BASEMENT REDESIGN MODIFICATION 4 SEDIMENT REDISTRIBUTION SUBMISSION TO DPIE - MARITIME HERITAGE – SSDA 8925

I have reviewed the Main Works SSDA Modification 4 Sediment Redistribution (SSDA 8925) in respect of impacts on underwater cultural heritage as addressed in the report titled “New Sydney Fish Market, Maritime Heritage Impact Statement” (COM-RPT-01) prepared by me and dated 27th March 2019. My assessment of the modifications are as follows:

- Area shown in blue is where the Hansen batching Plant and Wharf was located.
- Approximately 12,000m<sup>3</sup> of sediment requires redistribution within the Site.
- Previous reports prepared as part of the SSD submission referred to less than 1,000m<sup>3</sup>

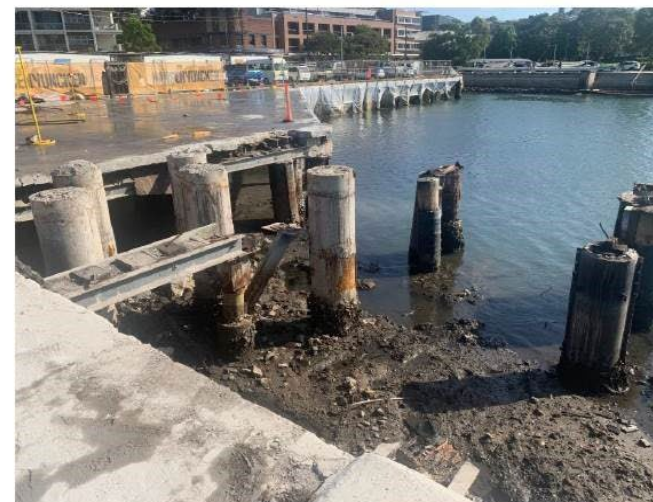
- The extent of sediment redistribution since preparation of the above report. At the time of the report, the estimate provided was for approximately 560m³ of sediment which would be moved and redistributed. That figure has now risen to 12,000m³ focused in the vicinity of the Hanson Concrete Dispatching Plant wharf.

- The increase in seabed disturbance through sediment redistribution has the potential for additional impacts on archaeological deposits which date back to the early industrial development at the head of Blackwattle Bay from 1886.

- To mitigate impacts, the following adjustments to the archaeological testing program are recommended:
 1. Two additional archaeological test trenches should be placed in the area that lay beneath the Hanson Concrete Dispatching Plant wharf. This is an area where new piling will be taking place for the Western Plaza.
